Our Ref: EN020032

Application by Morgan Offshore Wind Limited and Morecambe Offshore Windfarm Limited (“the Applicants”) for an Order granting Development Consent for the proposed Morgan and Morecambe Offshore Wind Farms Transmission Assets (“the Proposed Development”)

REQUEST FOR INFORMATION

**Figure 1.3: Temporary construction mitigation area at Lytham Moss**

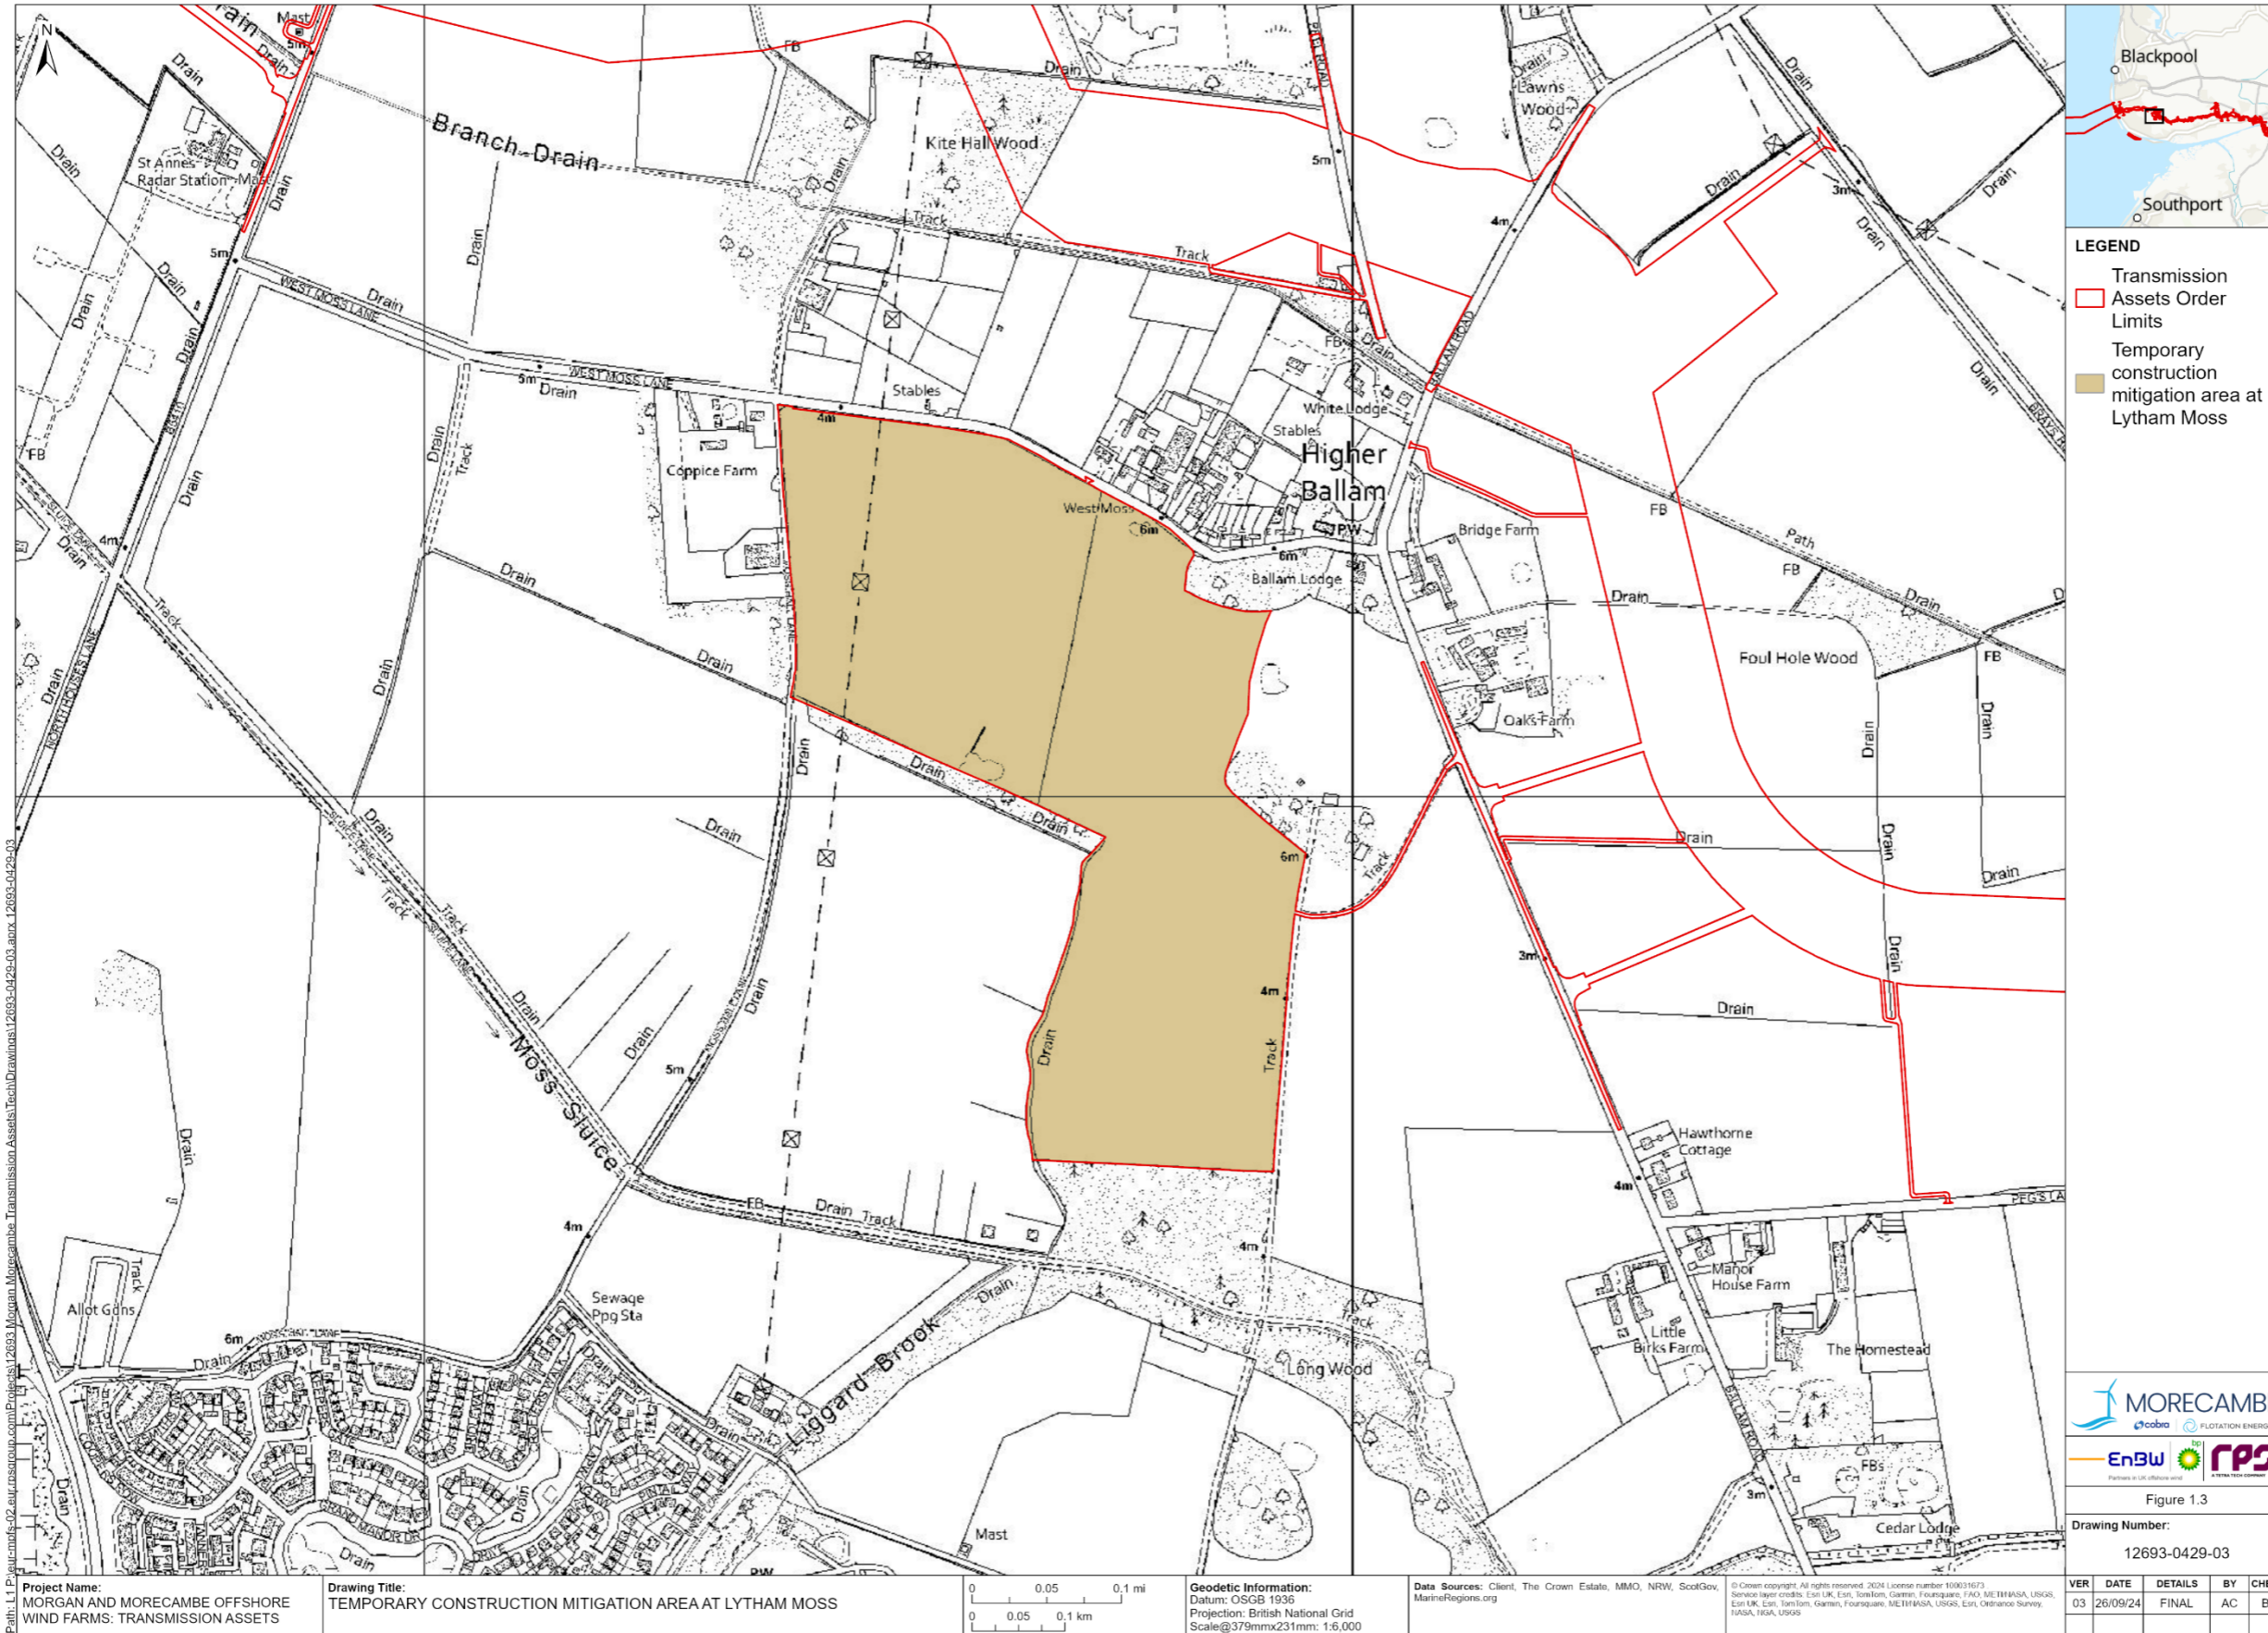
11. Without prejudice to Secretary of State's conclusions, the **Applicants** are requested to update documentation relating to CA, TP, and all other land powers, to amend the proposed order limits and dDCO if appropriate and remove all powers related to temporary mitigation areas in scenarios 1 and 2 e.g. temporary powers over plots 06-078 and 07-002 at Lytham Moss.

**Figure 1.6: Permanent mitigation area south of Newton-with Scales**

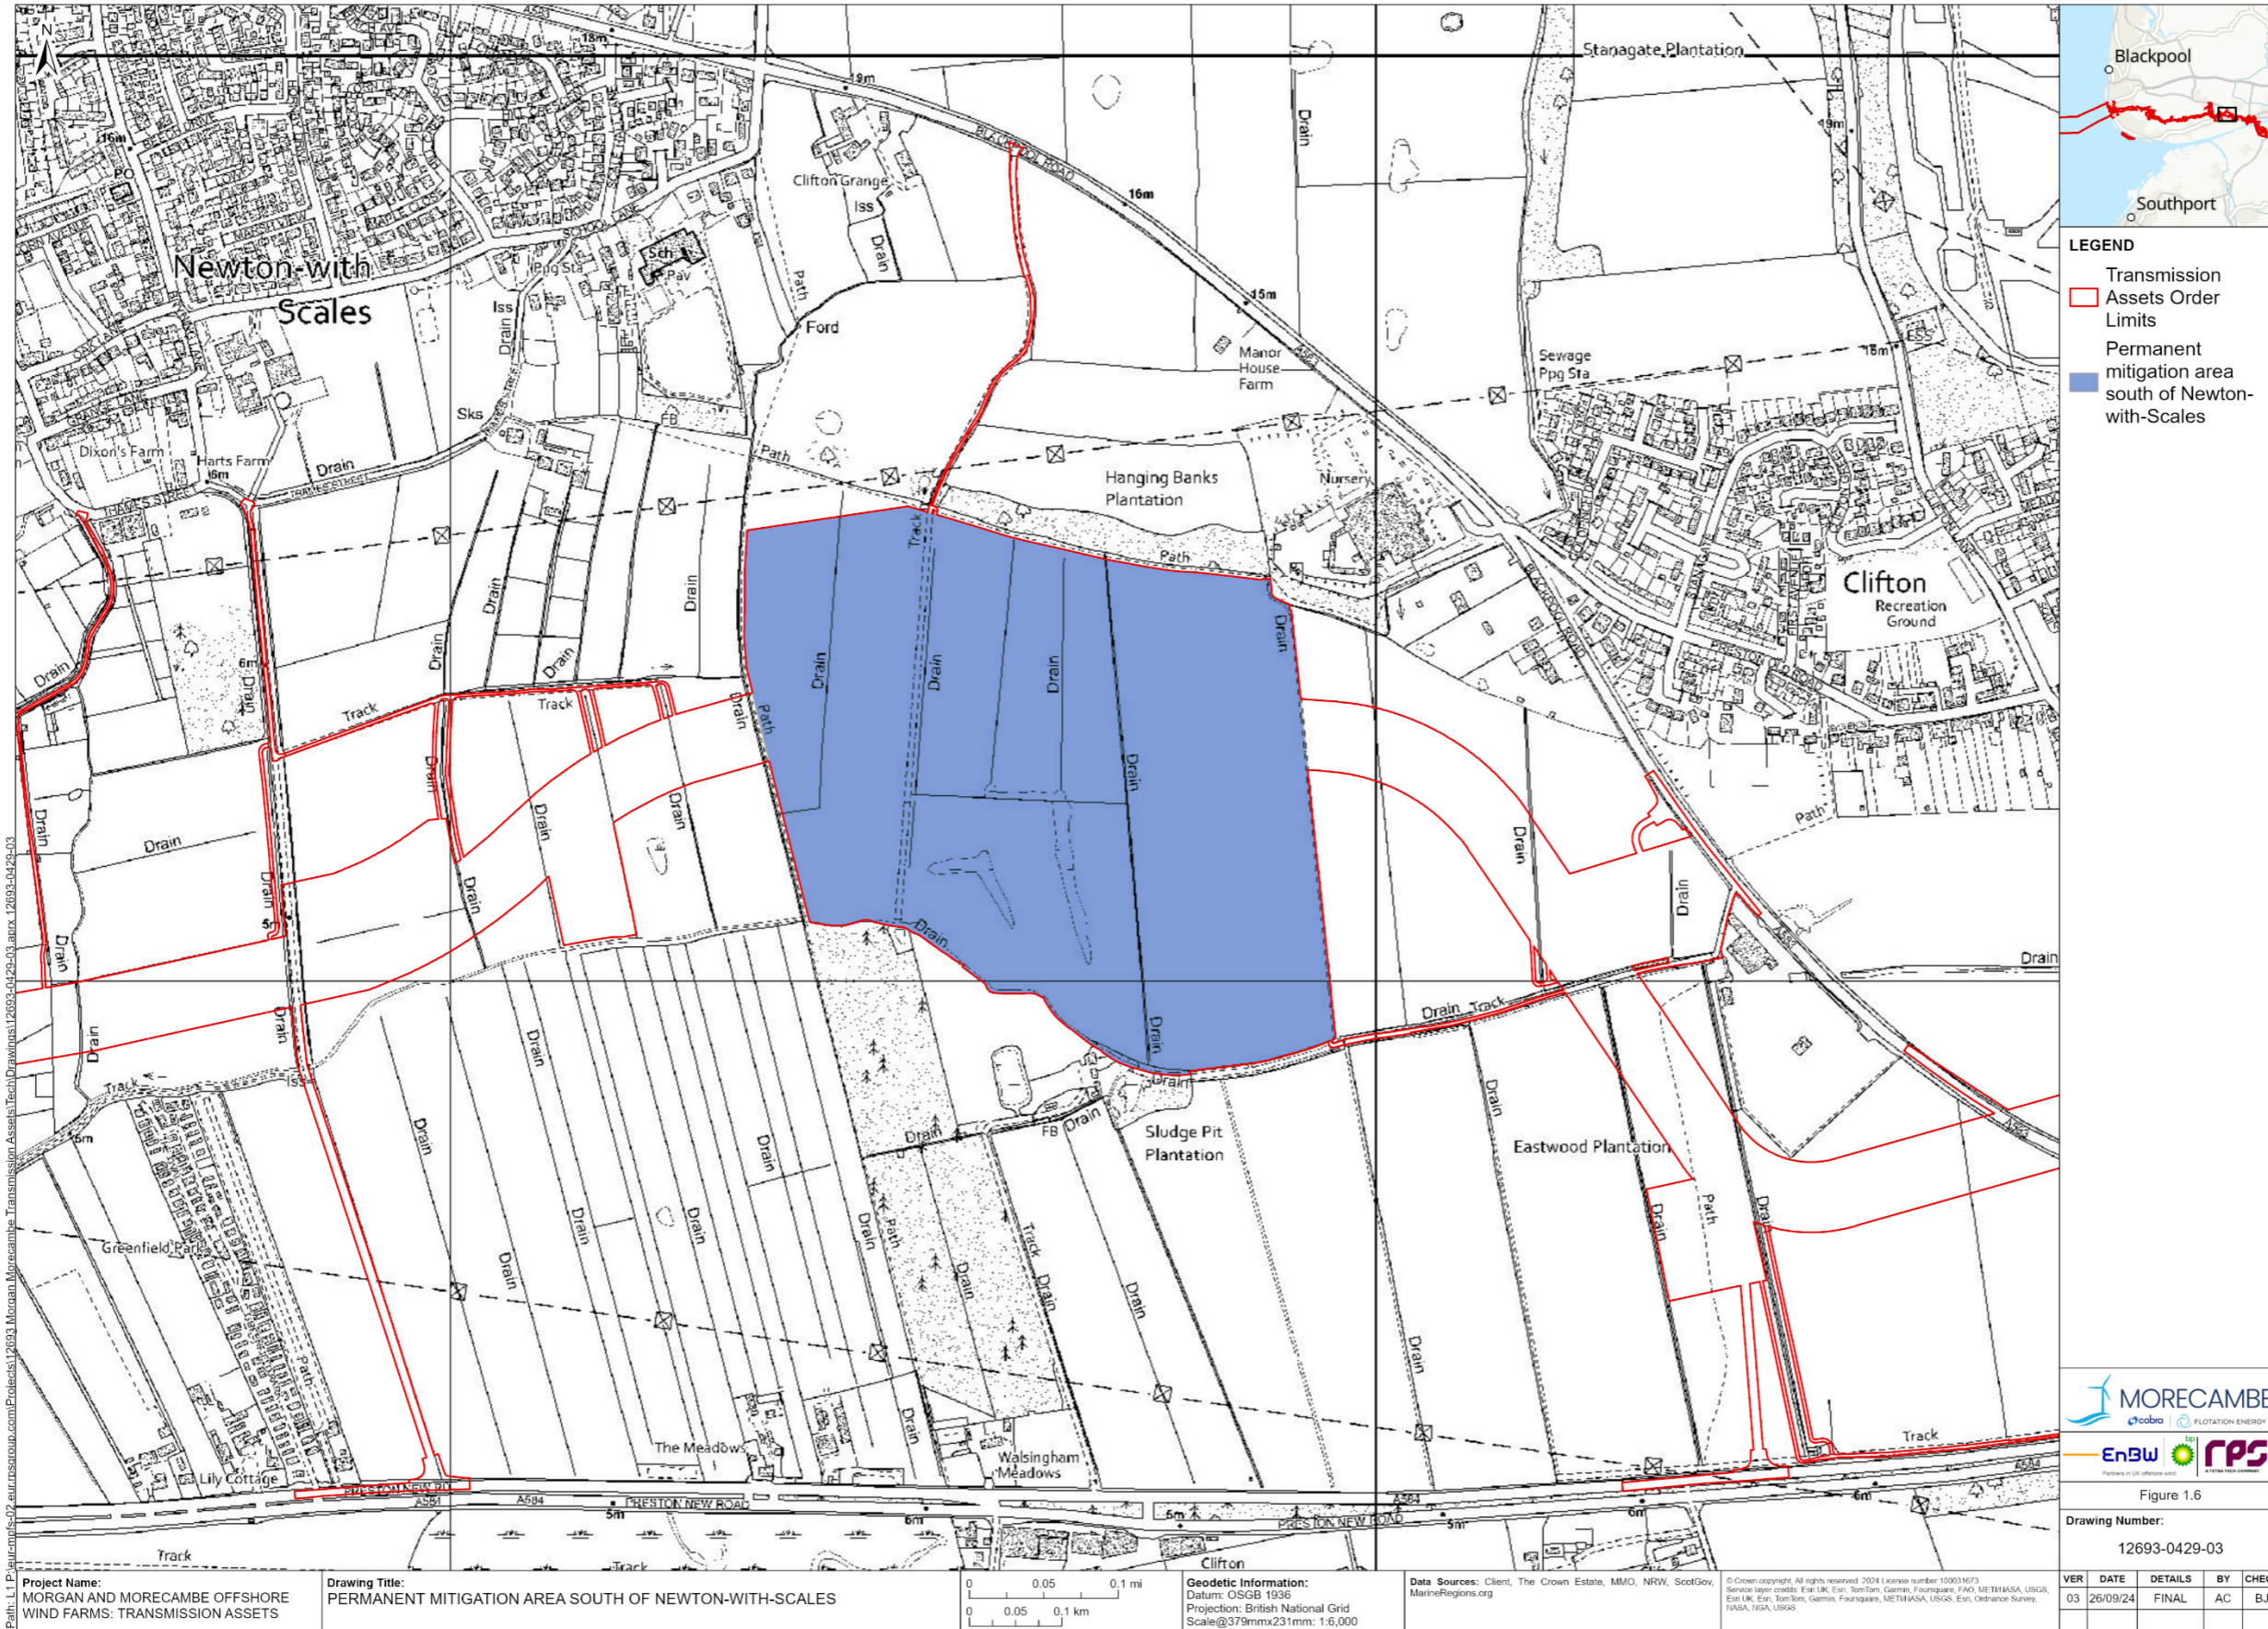
12. The **Applicants** are requested to confirm which plots at land south of Newton with Scales (currently plots 14-012A, 14-013A, 14-014 14-015, 14-016A, 14-017, 14-018, 14-019A, 14-020, 14-021, 14-025A, 14-026A, 14-027A, 14-030 for Morgan and 14-028B, 14-029B, 14-030, 14-031B, 14-032, 14-033B, 14 034B, 14-035 and 14-036 for Morecambe) are required to deliver the mitigation proposed for significant EIA effects, given the revised management proposals for the site. If any

changes are required, the Applicant is requested to update documentation relating to CA, TP, and all other land powers.
